Demolition of existing buildings & erection of 3 No. dwellings with associated parking,
alterations to existing access & relocation of staircase to flats.

Land Rear of Beechlands Cottages Beechlands Close East Preston

Thank you for your internet representation made on 19th November 2017 which has been recorded as '**no objection**' with the comments as follows:

Proposed Site Plan, Block Plan
and Location Plan

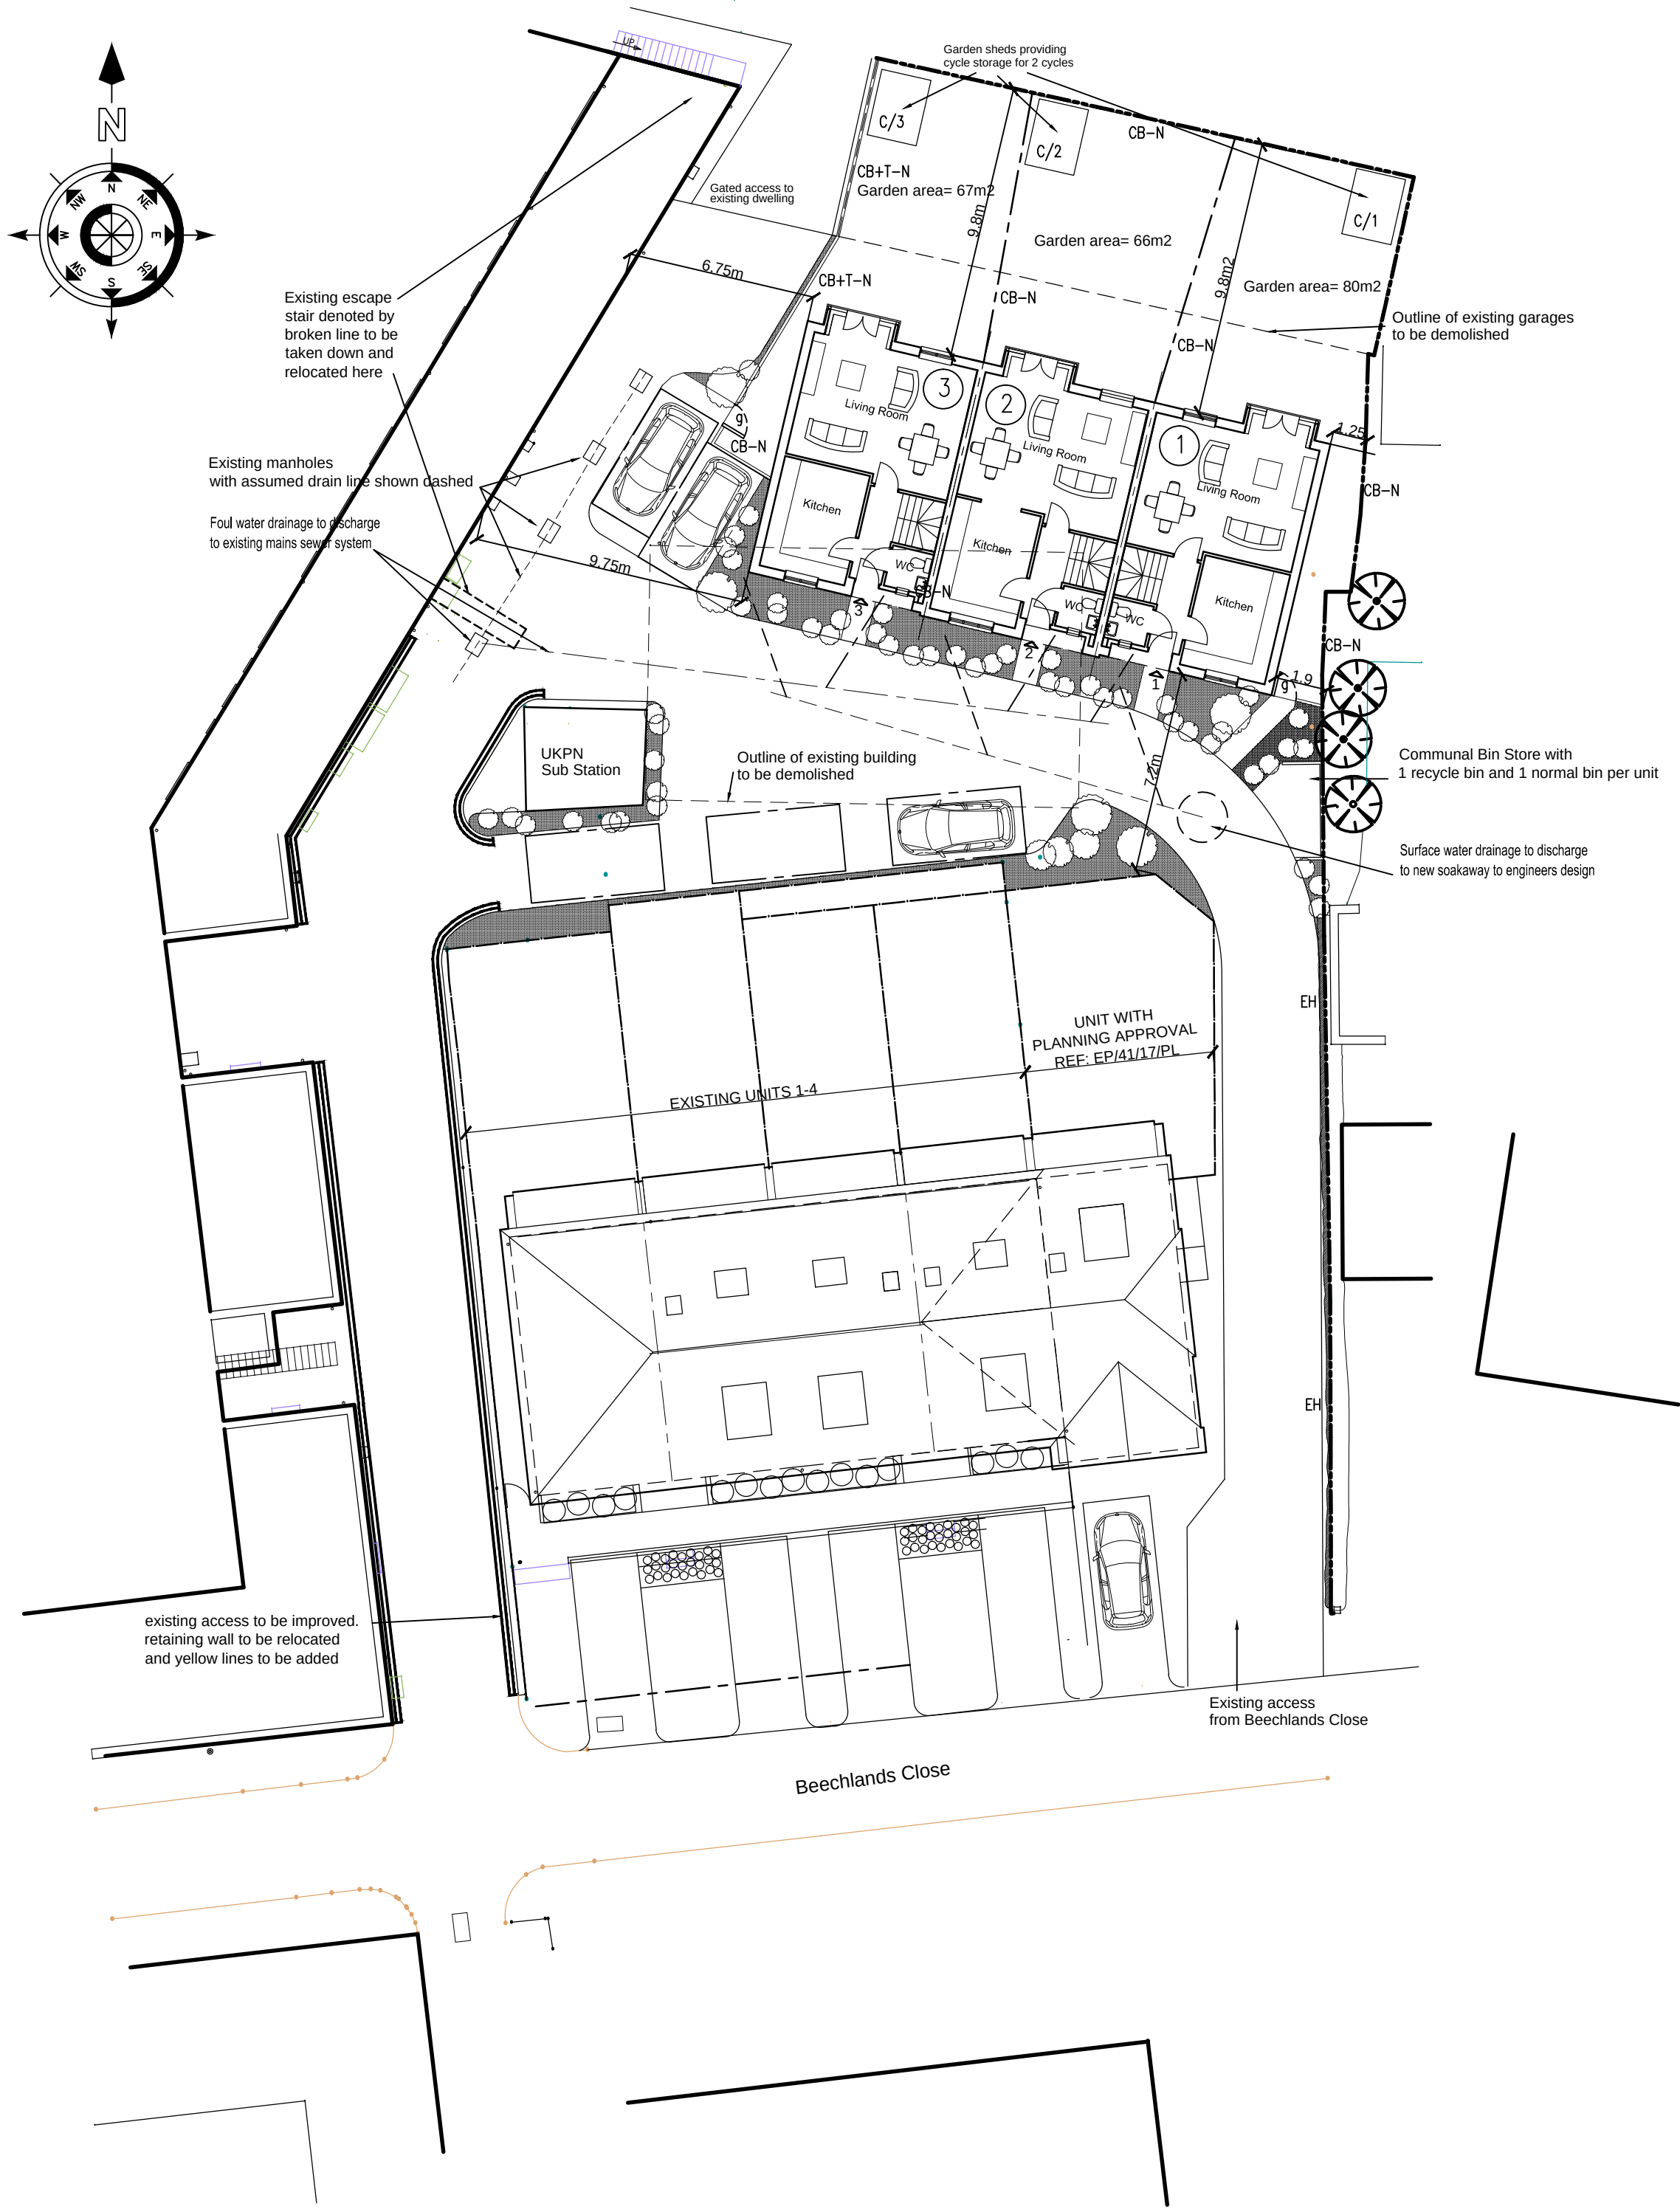
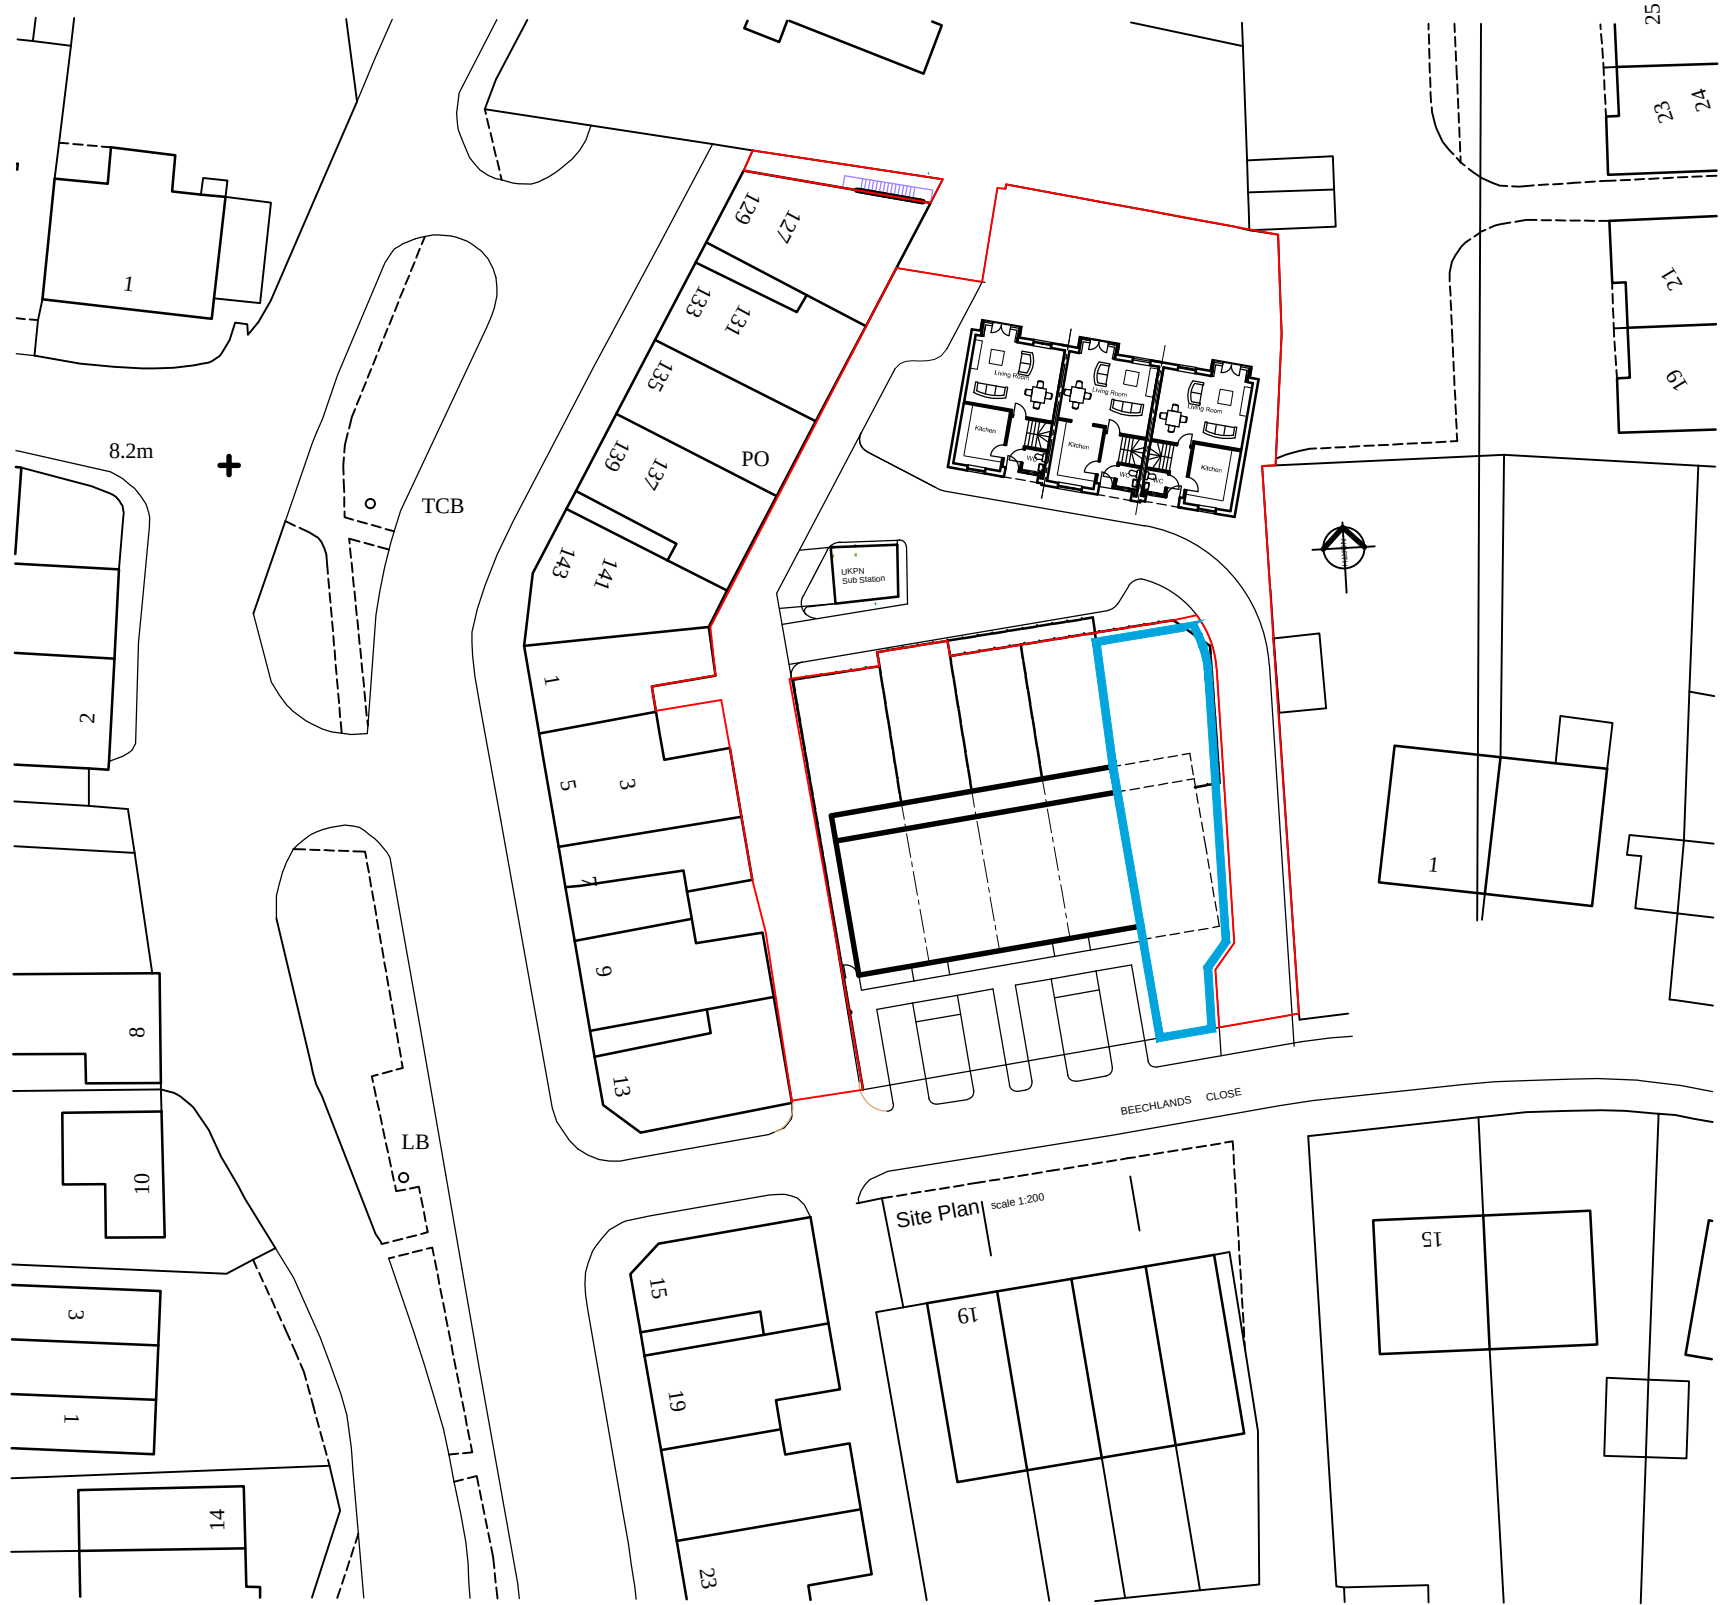
please ensure shop tenants 3/13 sea rd can adequately use their rear service road for loading unloading and parking in the light of the proposed widening scheme of this access road.
